## REQUEST

Current Zoning: N1-A (neighborhood 1-A)  
Proposed Zoning: R-8(CD) (residential, conditional)

Approximately 24.96 acres located on the south side of Allen Road East and east side of Citadel Place, west of Allen Road South.

The petition proposes a residential community of up to 84 single-family attached townhouse style dwelling units.

TITLE  
PRELIMINARY SITE PLAN  
R-8 (CD)  
RZP\_2023\_011

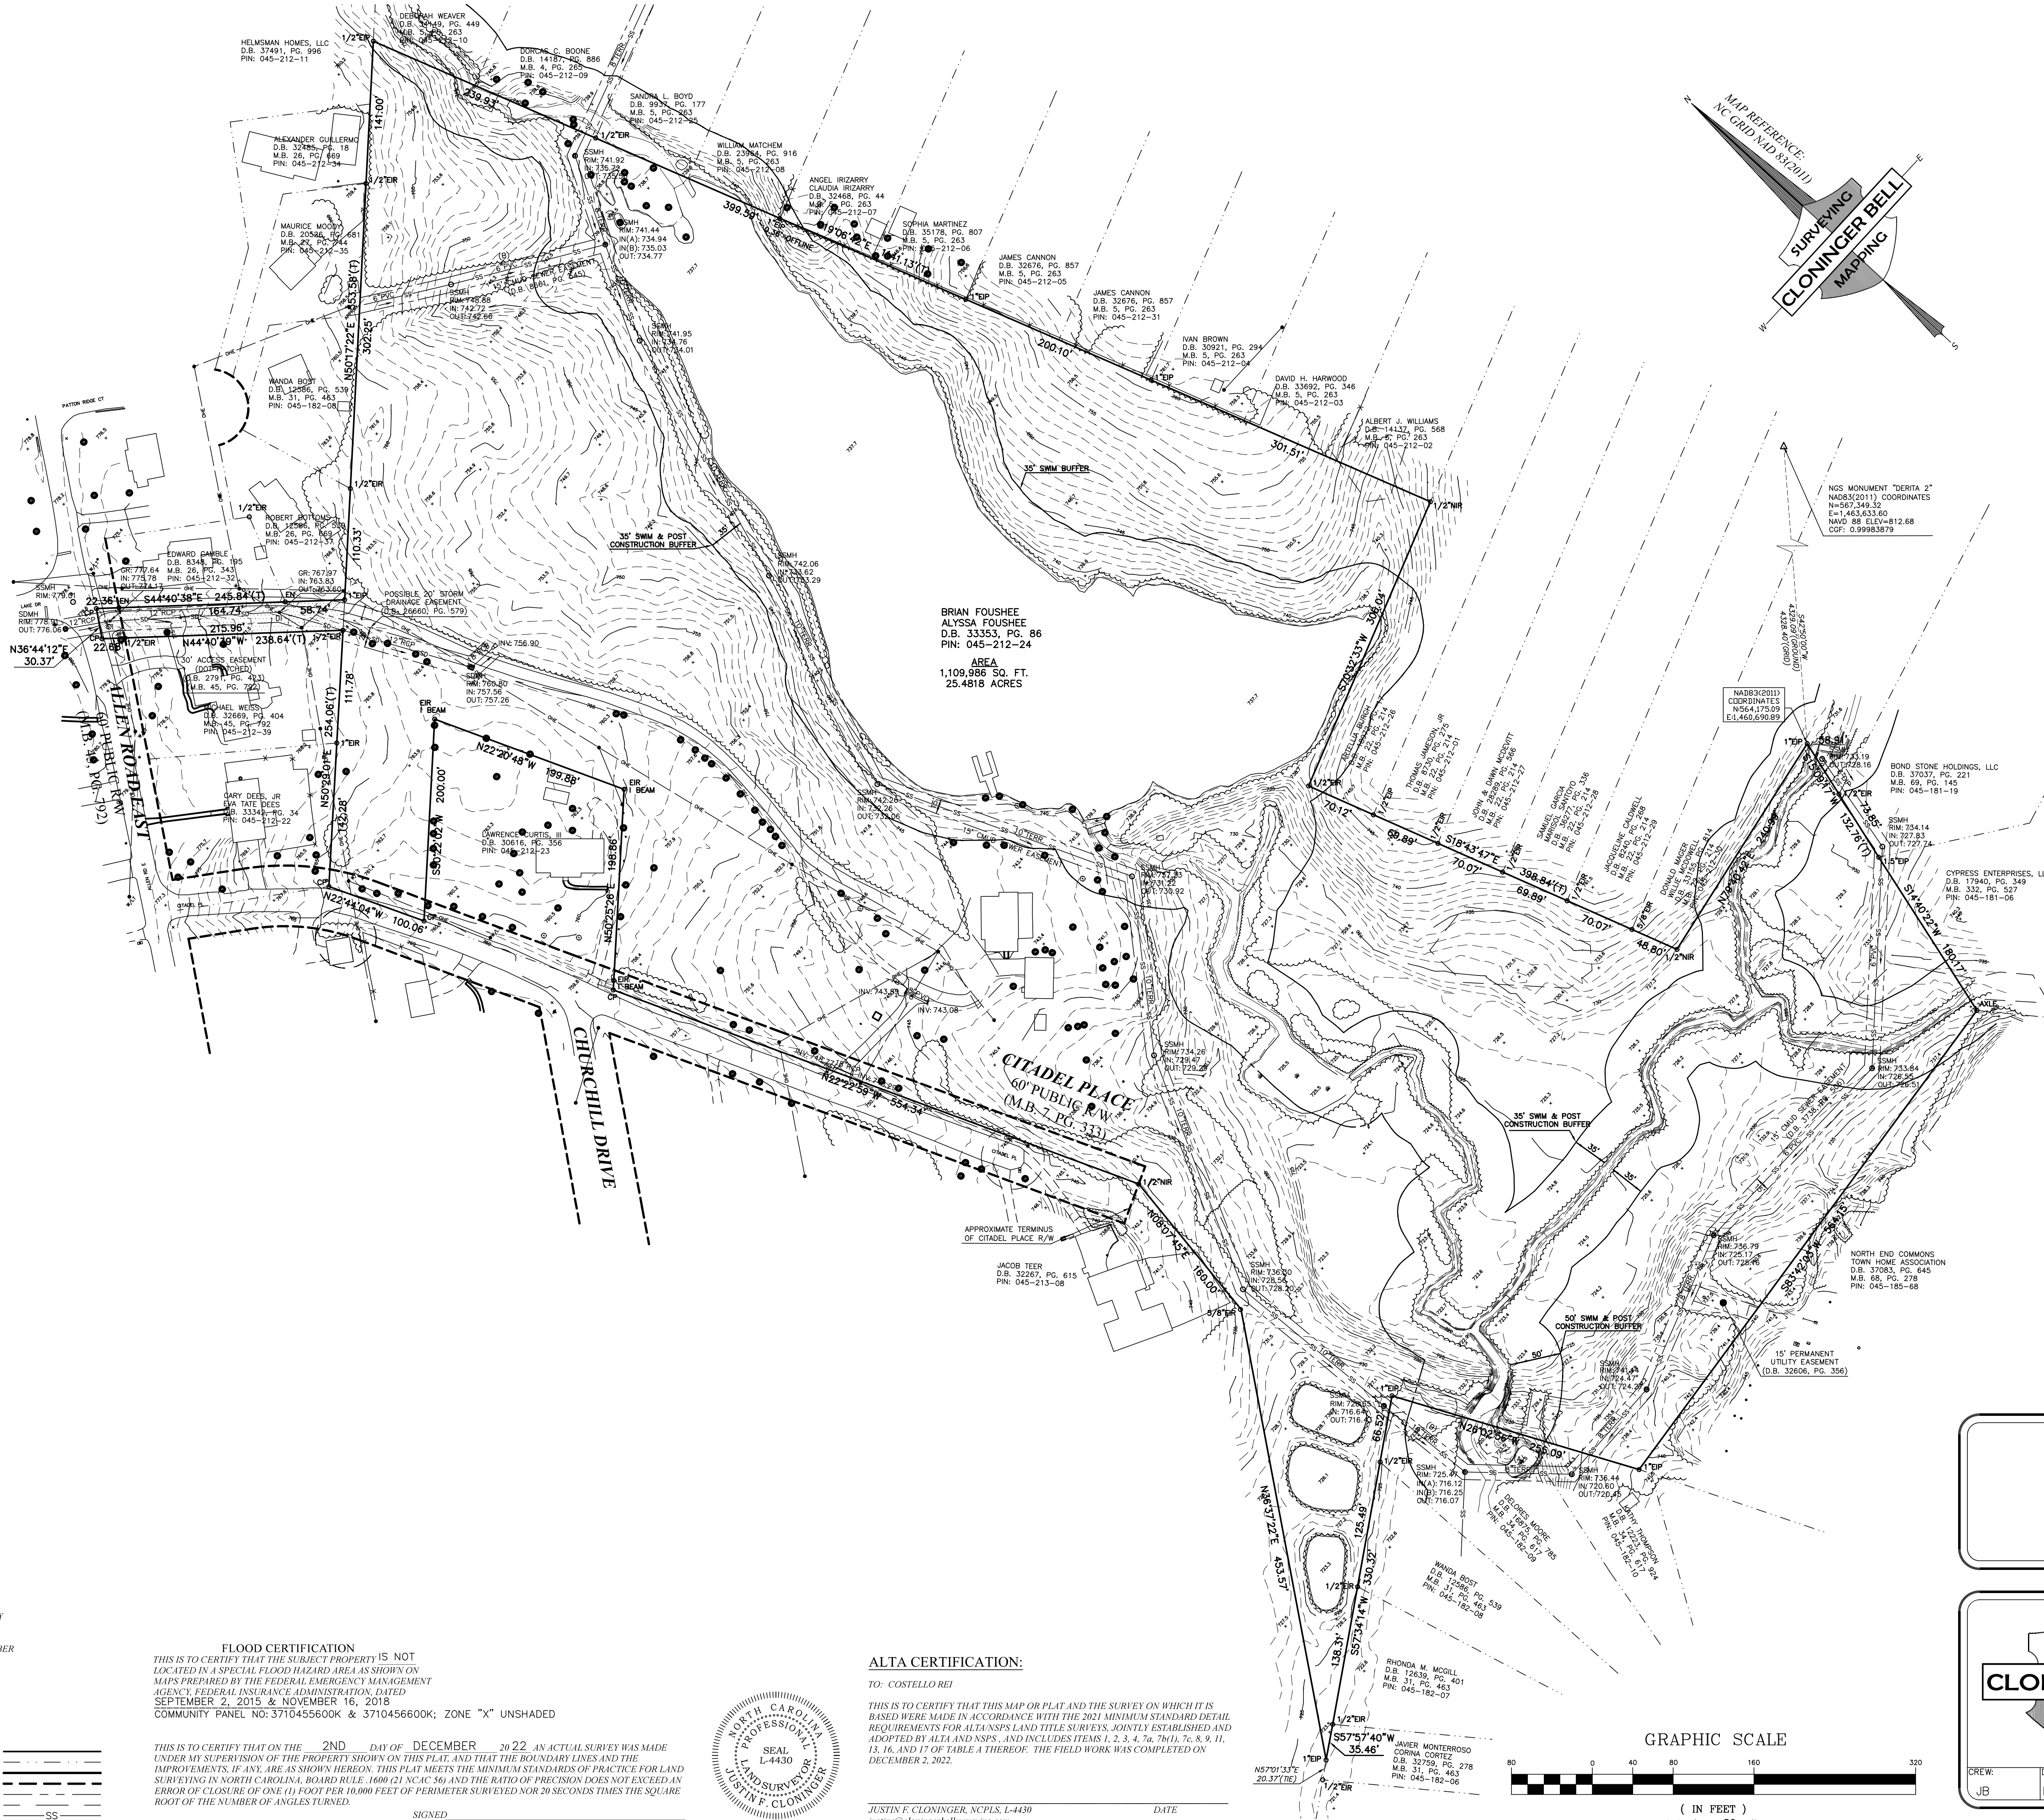
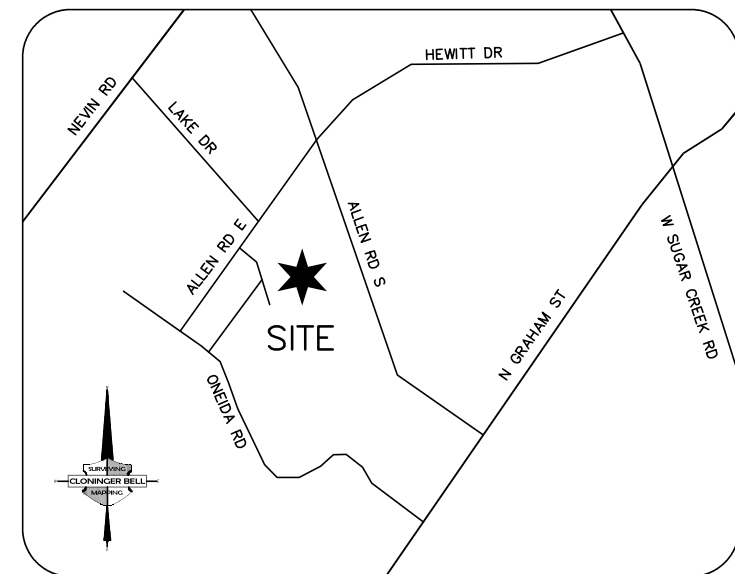
- ~~1. Reduce unit count and incorporate a mix of buildings that better align with the N1 Place Type (duplexes, triplexes).~~ Addressed
- ~~2. Relocate proposed dumpster location away from existing houses.~~ Addressed
- ~~3. Add visitor parking areas.~~ Addressed

- Allows up to 84 80 dwelling units in a townhouse style.
- Proposes duplexes and triplexes.
- Trash pick-up will be provided by roll-out carts.
- Provided a wetlands clarification letter.
- Provides an 8-foot planting strip and 6-foot sidewalk along the site's frontage on Citadel Place.
- Provides an 8-foot planting strip and 6-foot sidewalk on all internal streets.
- Provides a 30-foot right-of-way along Citadel Place from the centerline of the road.
- Dedicates a minimum 1.25 0.80 acres to Mecklenburg County for a future neighborhood park.
- Provides architectural standards.

- ~~4. Revise the park note to read: "land to be dedicated and conveyed to Mecklenburg County."~~ Addressed
